re: Geotechnical Response to City Comments
Proposed Building Addition
1250 and 1252 Wellington Street West – Ottawa, Ontario

file: PG5972-MEMO.01

Further to your request, Paterson Group (Paterson) prepared the current memorandum to address the geotechnical related review comments provided by the City of Ottawa. The following memorandum should be read in conjunction with the current Geotechnical Investigation Report (Paterson Group Report PG5972-1 Revision 1 dated March 15, 2022).

DRAWING TITLE
 GRADING AND DRAINAGE PLAN

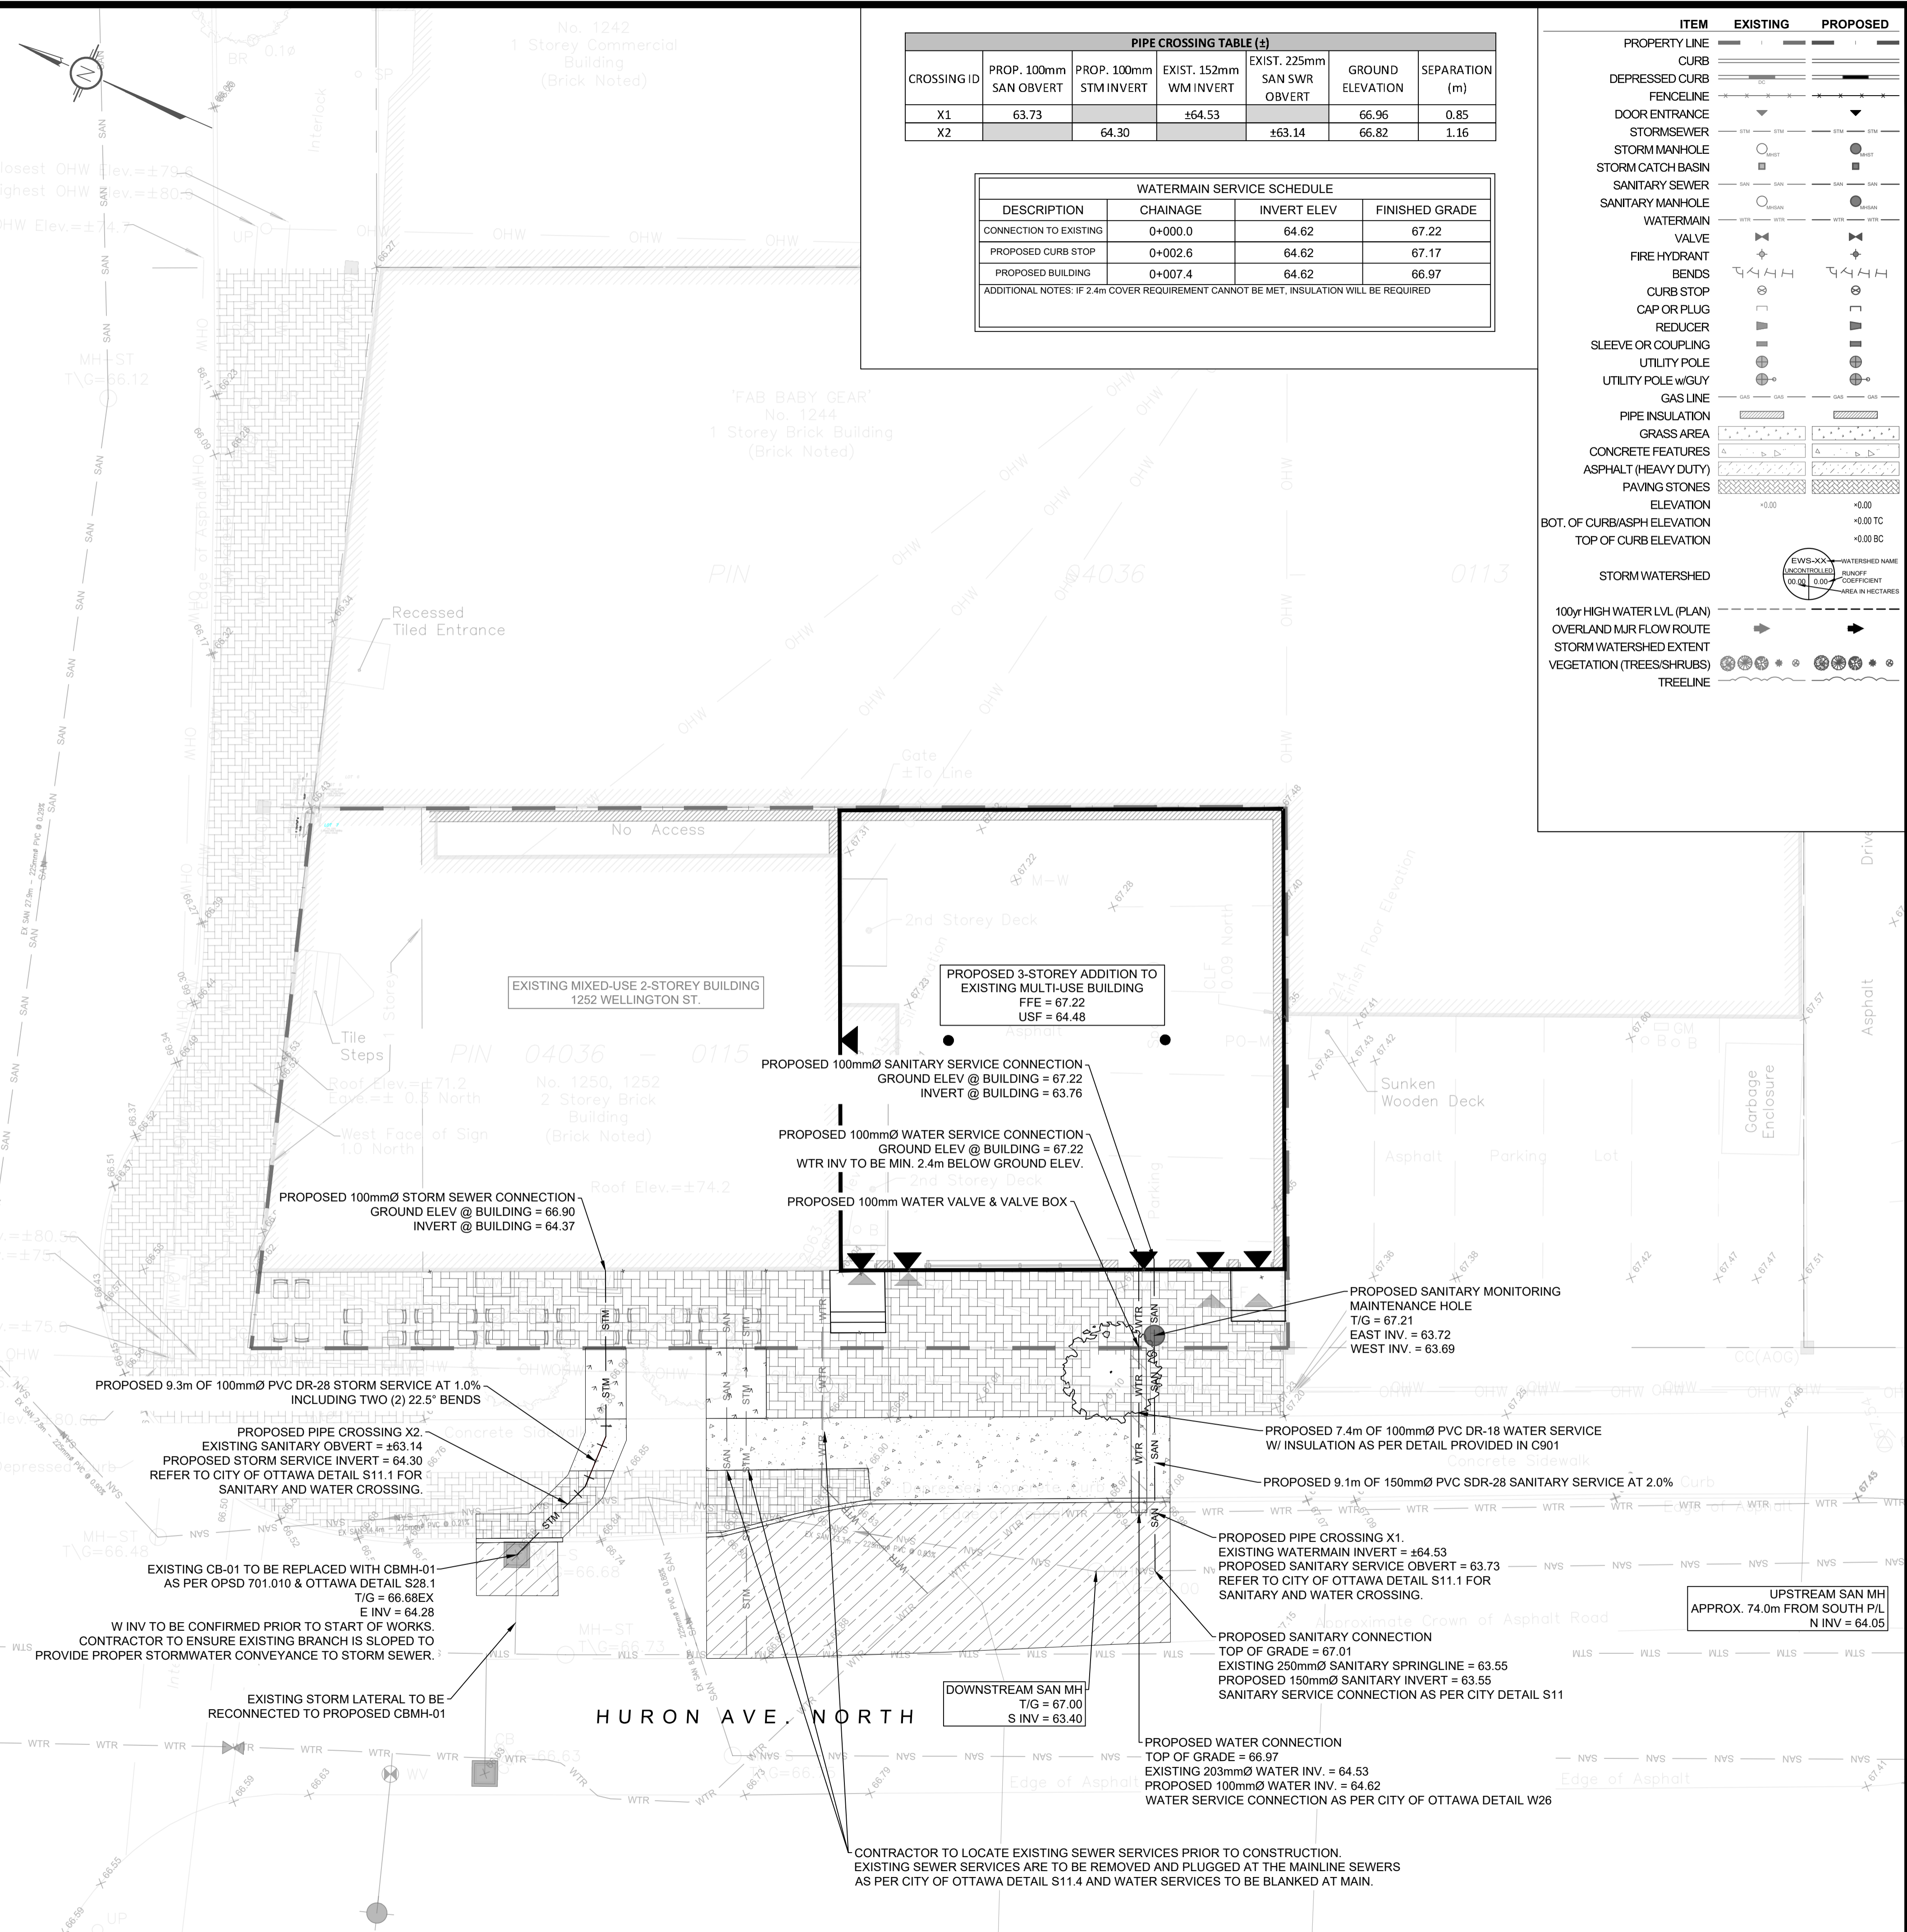
Comment 2.6: *Please submit a letter stating that the latest Grading and Servicing Plan has been reviewed and that it complies with the recommendations and statements of the latest Geotechnical Investigations*

Response: Reference should be made to Paterson Group Memo PG5972-MEMO.02, dated September 12, 2022, which documents our review of the latest site servicing and grading plans for the subject site provided by LRL Associates Ltd. In summary, the proposed grading at the subject site has been reviewed and is considered acceptable from a geotechnical perspective. In addition, the site servicing plans have incorporated the relevant geotechnical recommendations as part of the design. Therefore, the latest grading and site servicing plans are considered acceptable from a geotechnical perspective.

HOLE NO. **BH 1-21**

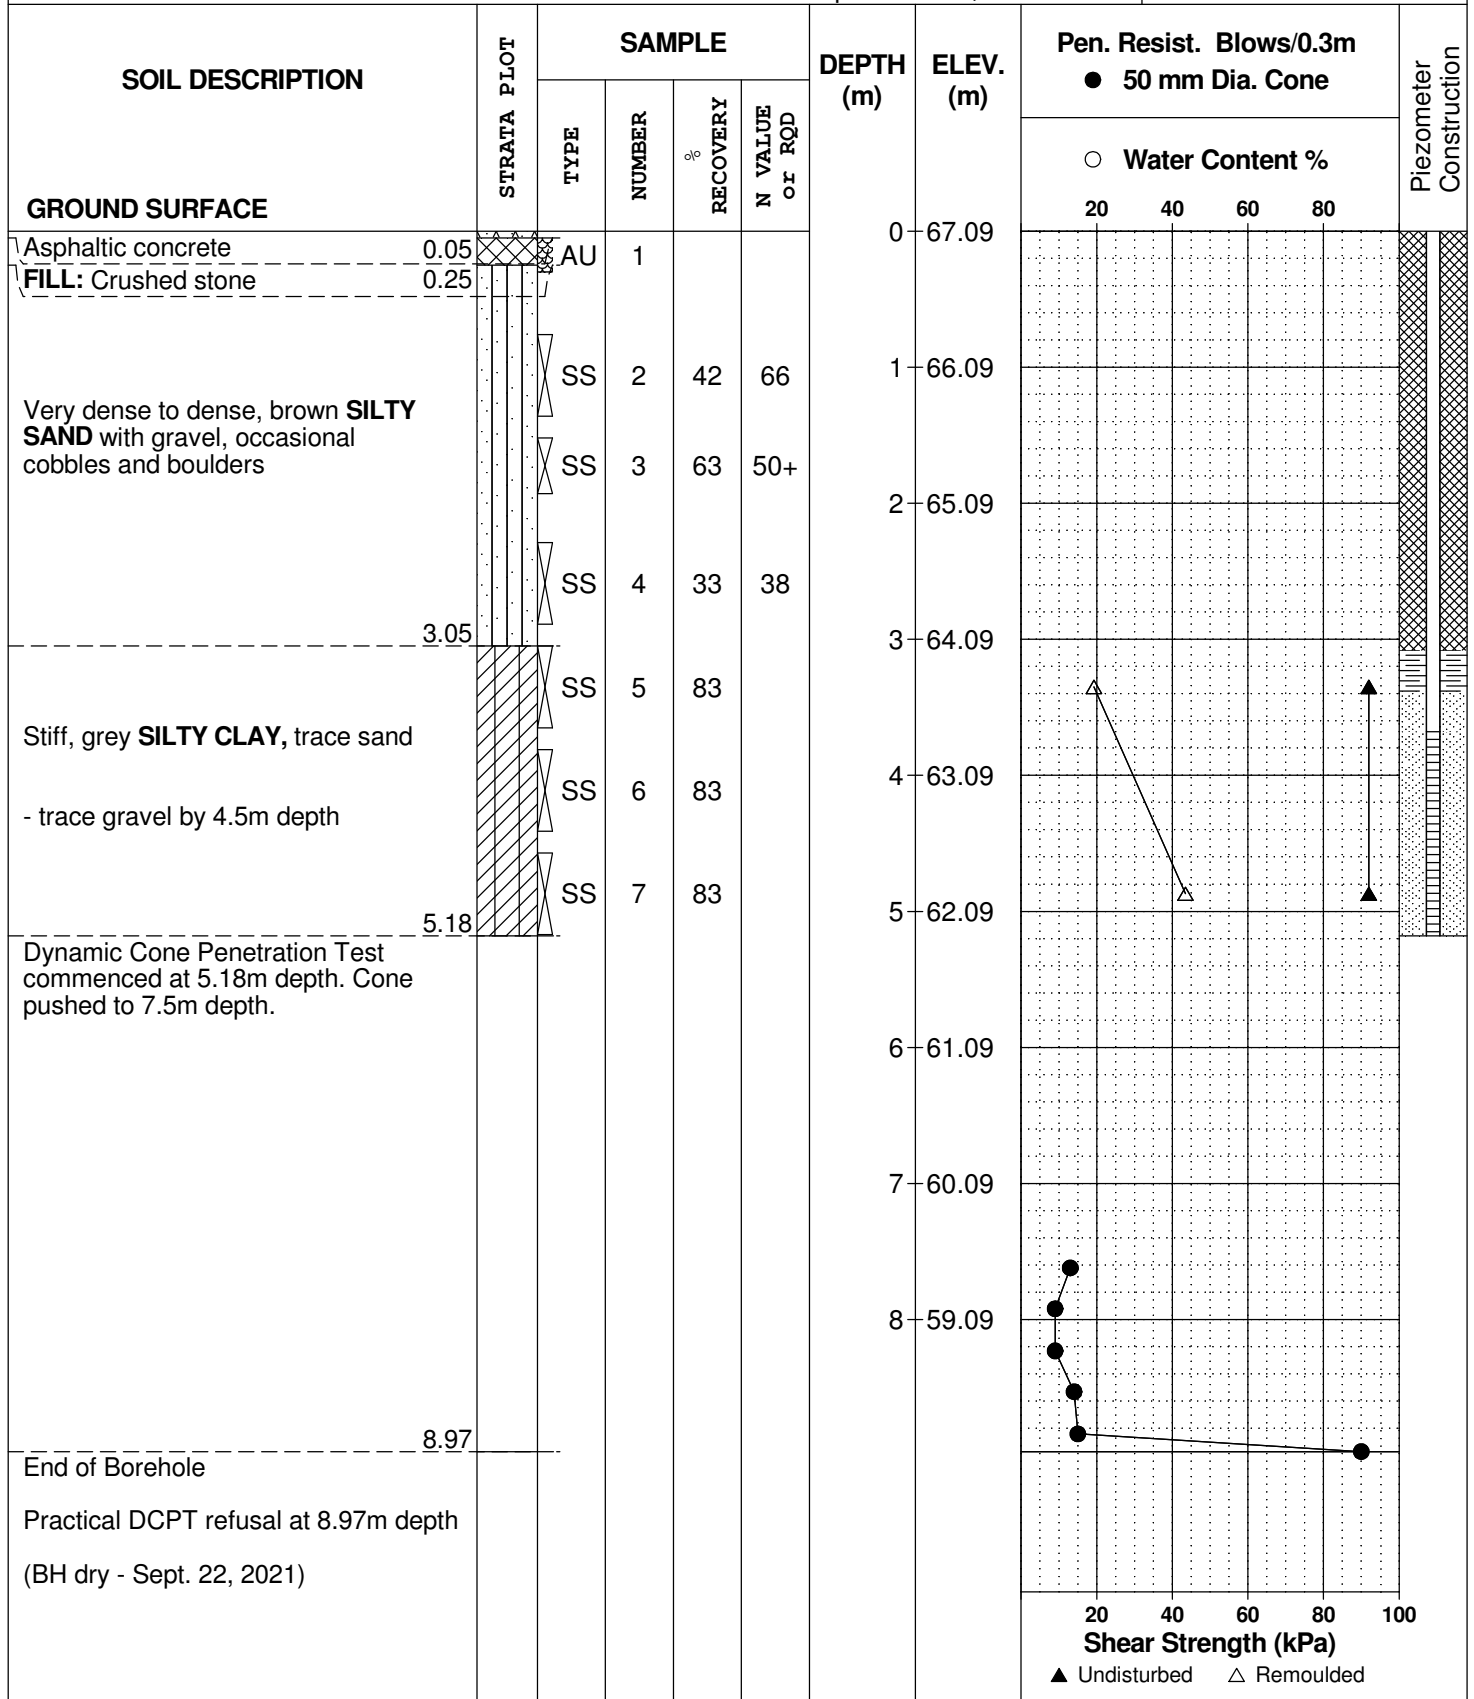
Comment 2.5: *Please provide discussion on the measured groundwater level readings in relation to the proposed underside of footing for the proposed buildings.*

Response: Groundwater levels were measured at a depth of 2.9 m below ground surface at BH 1-21 on September 22, 2021, within the installed piezometers. However, all other piezometers and test pits extended below this depth were observed to be dry at the time of the investigation.

Based on the findings of the field investigation program, the long-term groundwater table at the subject site is anticipated at approximate depths of 3 to 4 m below ground surface. Based on our review, the proposed structure will be founded upon an undisturbed, compact silty sand bearing surface above the long-term groundwater table. Given this, the recommendations provided in Section 5.3 – *Foundation Design* and Section 6.1 – *Foundation Design and Backfill* of the current Geotechnical Investigation Report are considered suitable for the proposed development with respect to the long-term groundwater table depth.

LANDSCAPE PLAN LEGEND

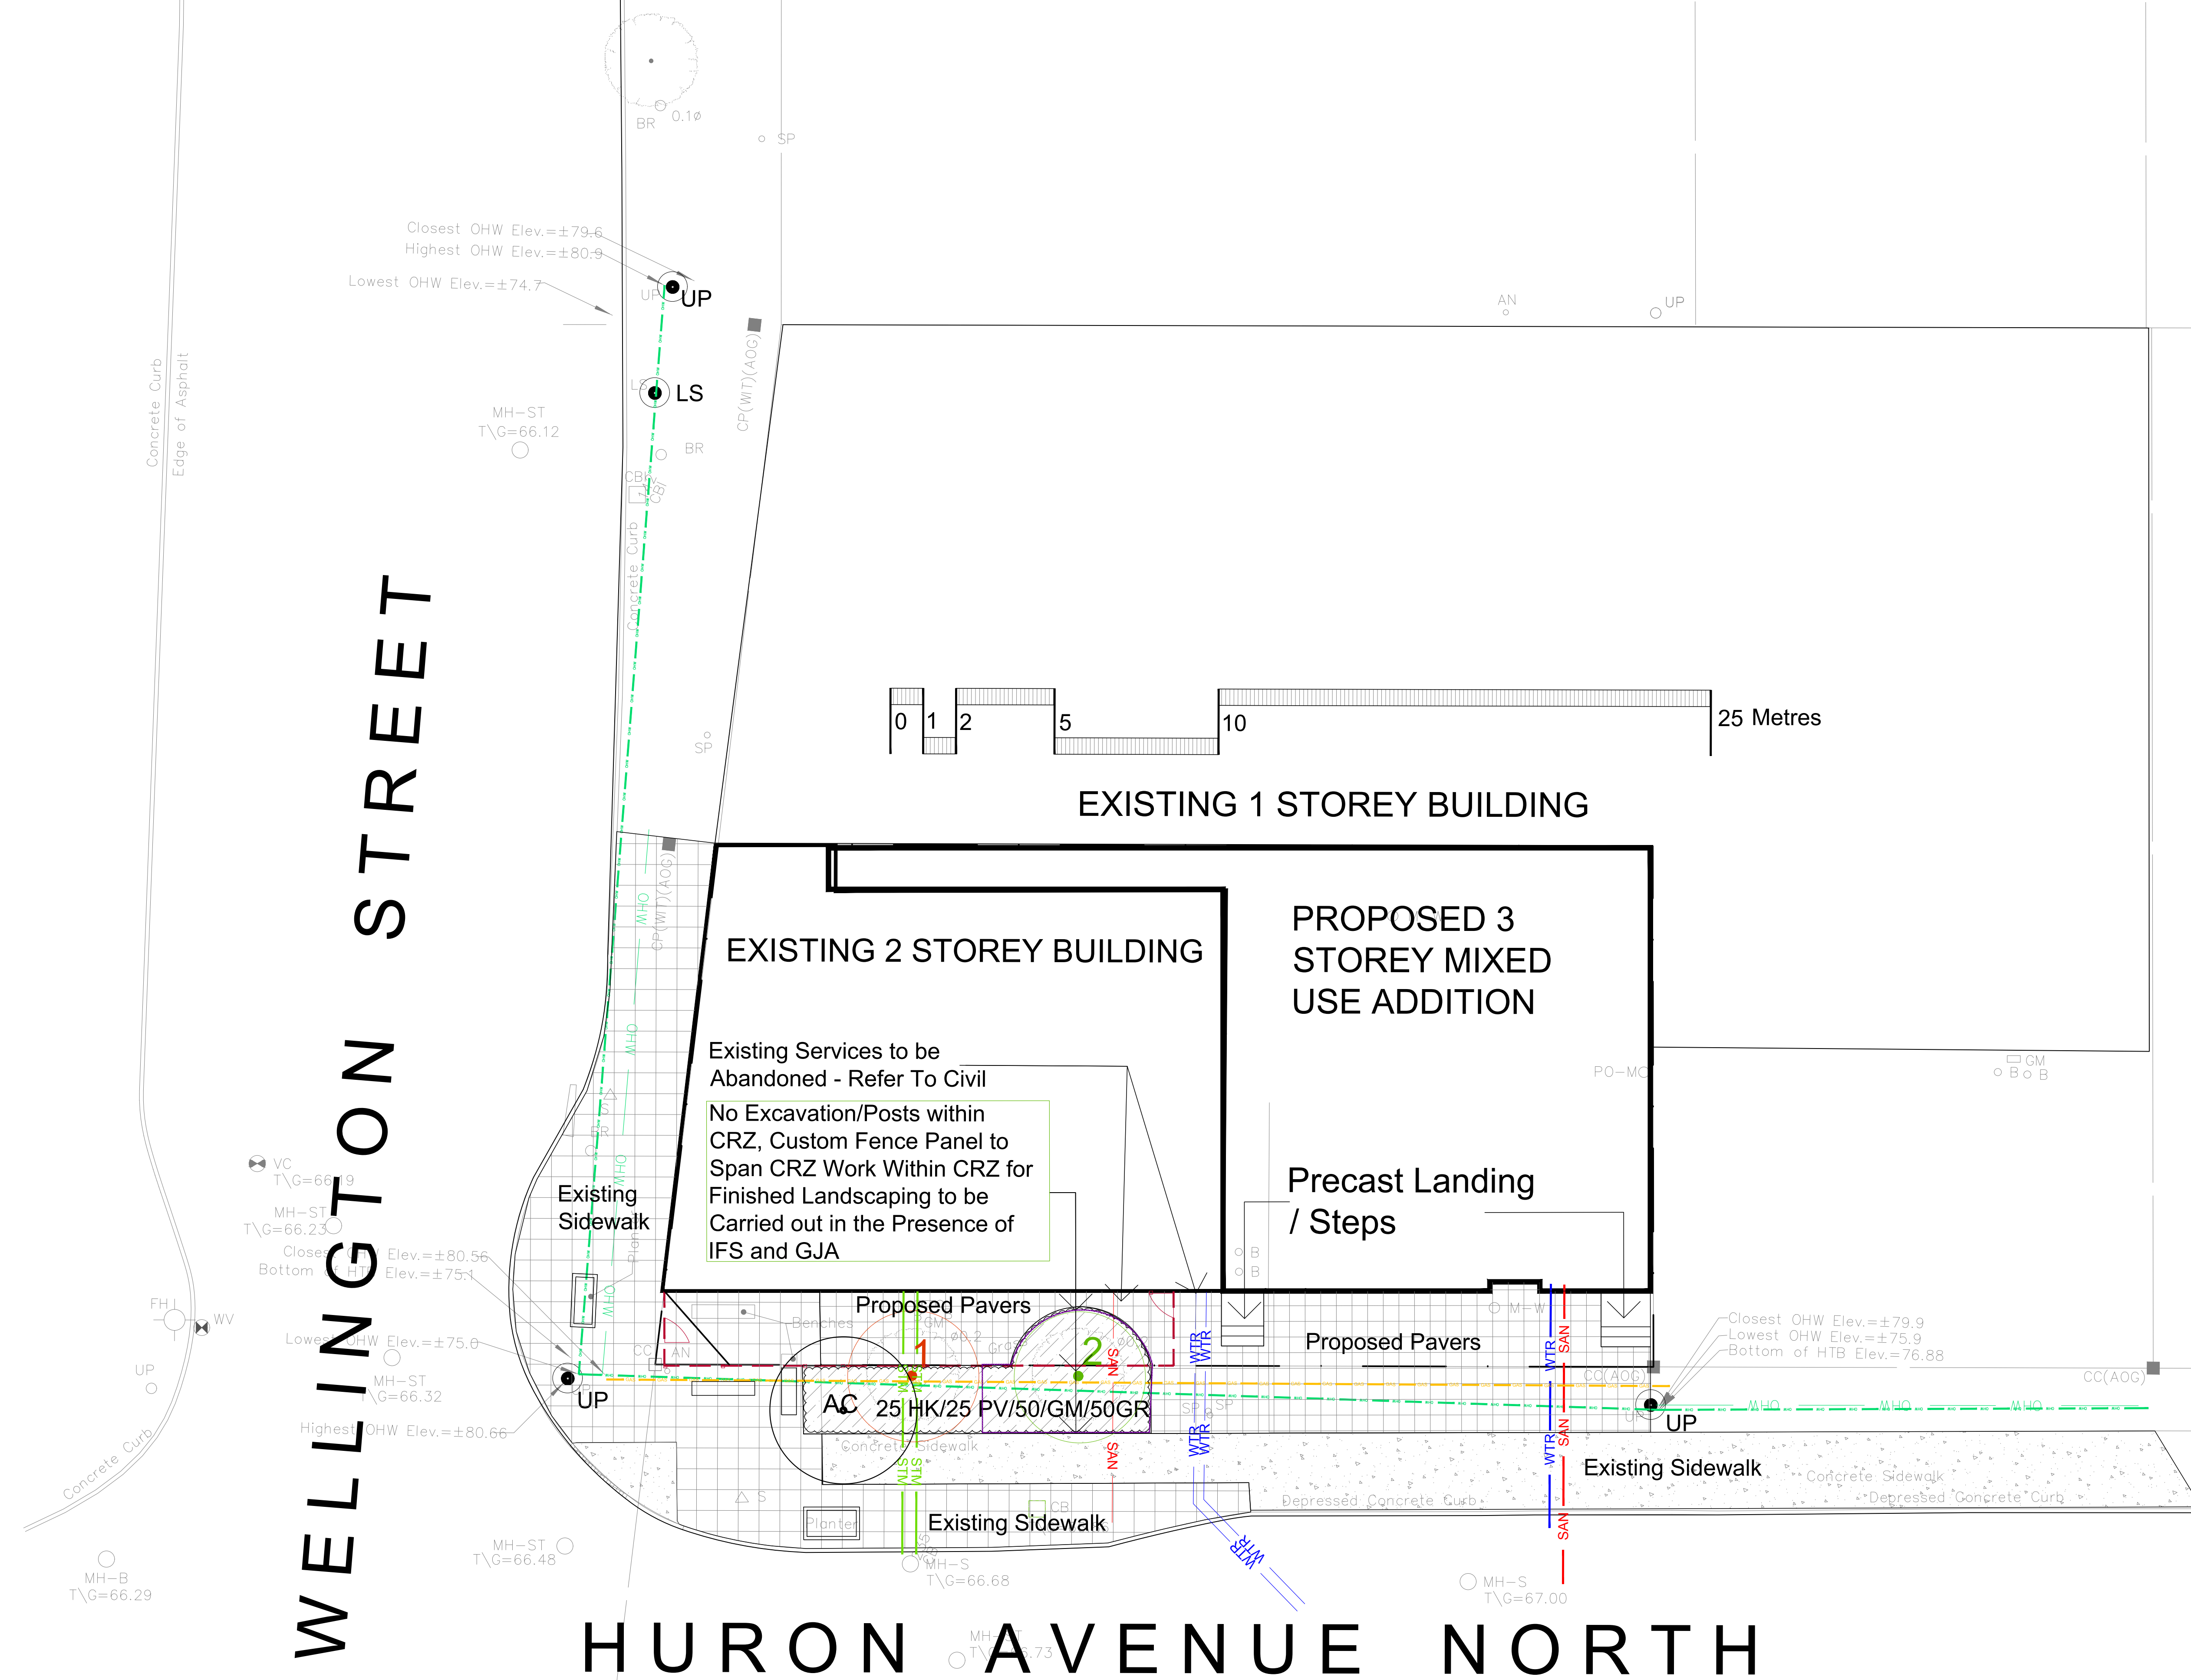
Comment 2.4: *As per Tree Planting in Sensitive Marine Clay Soils – 2017 Guidelines, in areas of clay soils, the followings tests are required, please ensure the following tests are performed*

- *Atterberg Limits test and one water content test*
- *A grain size test for every four boreholes*
- *A grain size test for every four boreholes*
- *Shrinkage test (These tests were not included silty clay present).*

Response: Based on our review of the landscape plan prepared by GJA Inc., it is understood the proposed landscaping will consist of a new shrub and retaining two existing Hackberry trees. The existing and proposed founding depth for the existing and proposed portions of the structures are understood to be located a minimum of 2.1 m below ground surface, and as required by the City of Ottawa's *Tree Planting in Sensitive Marin Clay Soils (2017 Guidelines)*. Further, the bearing surface was observed to be and is anticipated to consist of a layer of silty sand and gravel for the existing and proposed portions of the structure, respectively. The silty sand deposit is not considered susceptible to settlement associated with moisture depletion by tree roots and is expected to act as a barrier to root growth from extending into the underlying deposit of silty clay.

Since the proposed shrubs are not anticipated to have a similar water demand as street trees, setbacks based on the aforementioned guidelines are not considered applicable for the proposed development. It is expected the mature height of the proposed shrubs will be less than the setback provided between their footprint and the buildings foundation.

Based on this, the proposed shrubs are considered acceptable to be planted in their proposed location without impacting the proposed building from a geotechnical perspective. It is recommended seasonal pruning and maintenance of the existing Hackberry trees be considered to limit their long-term water demand.
